## *Rezoning Petition Review*

**Rezoning Petition #:** 20-123

**Location of Property:** Approximately 13.22 acres located along the Business Center Dr, west of Little Rock Rd and east of Moores Park Dr.

October 12, 2020

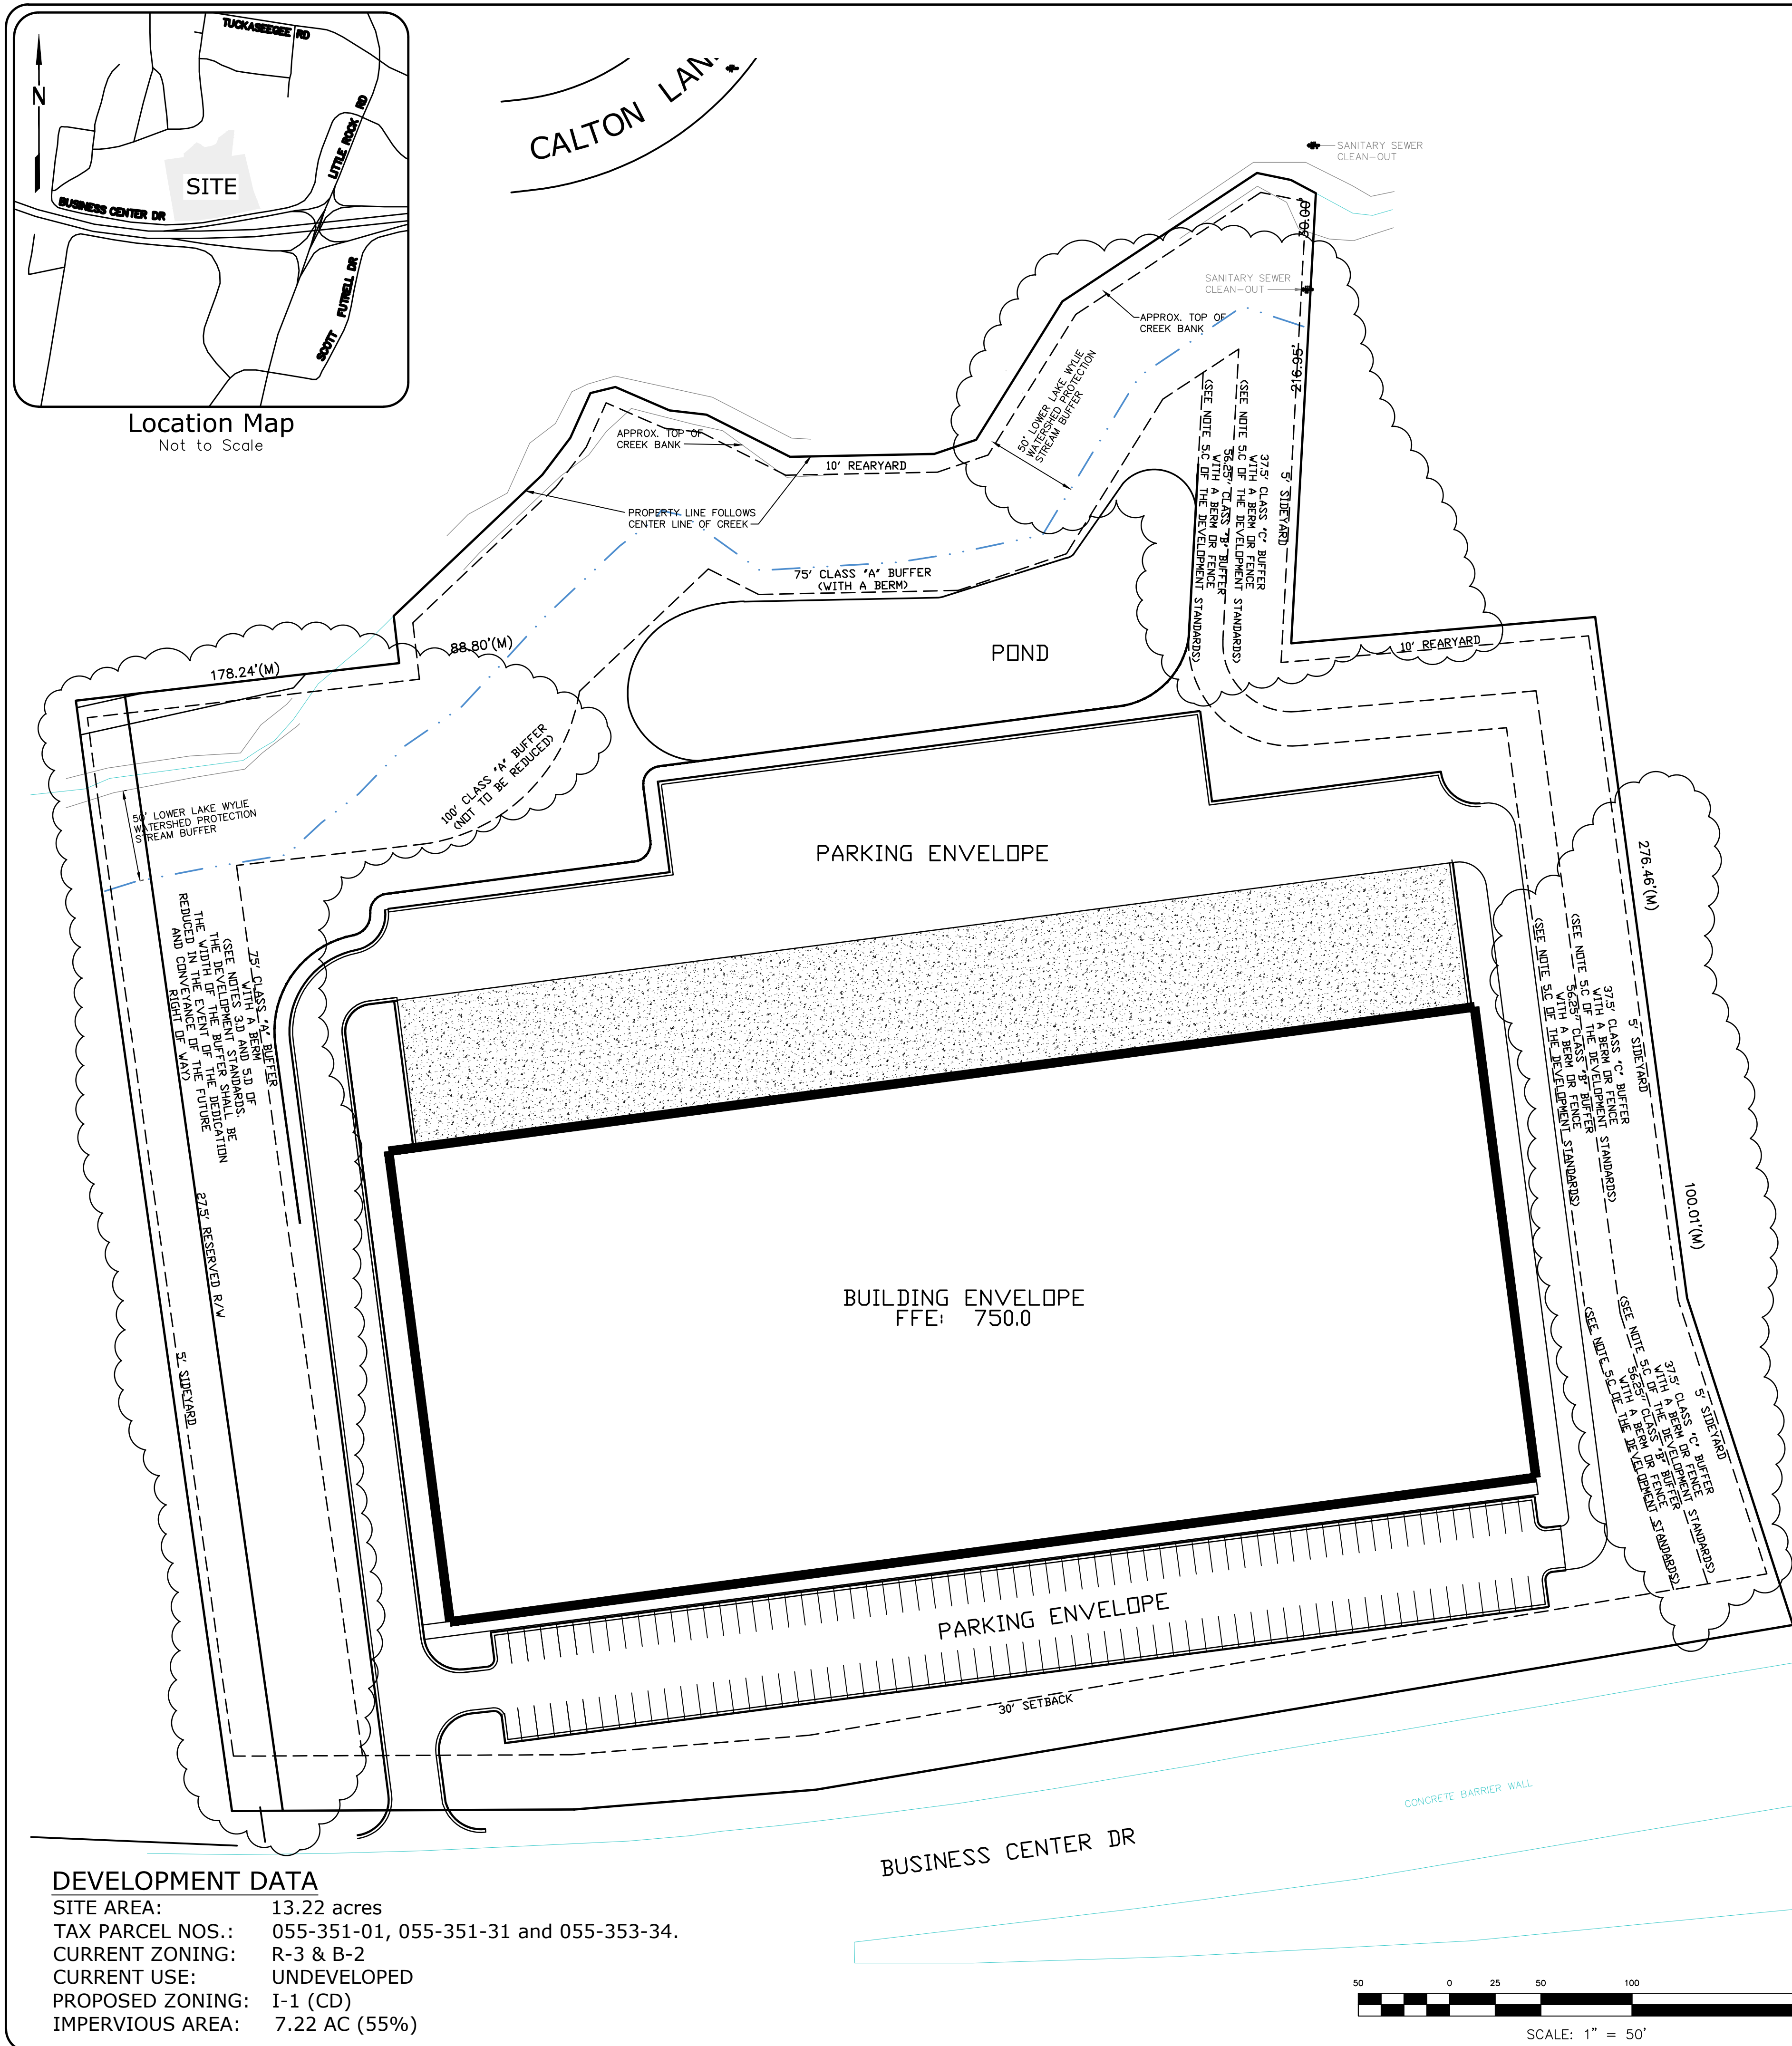
**Concerning Storm Water:** City of Charlotte GIS data indicates a 35-PCSO Buffer on site. Please show and label this buffer on the site plan.

This petition is located within the Protected Area of the Lower Lake Wylie Watershed Overlay District. The rezoning plan sheet calls out a 40-ft SWIM Buffer on site. Please revise to a Watershed Buffer. Also note depending on the project density this could be a 40-ft or 100-ft Watershed Buffer and subject to Watershed Overlay District requirements.
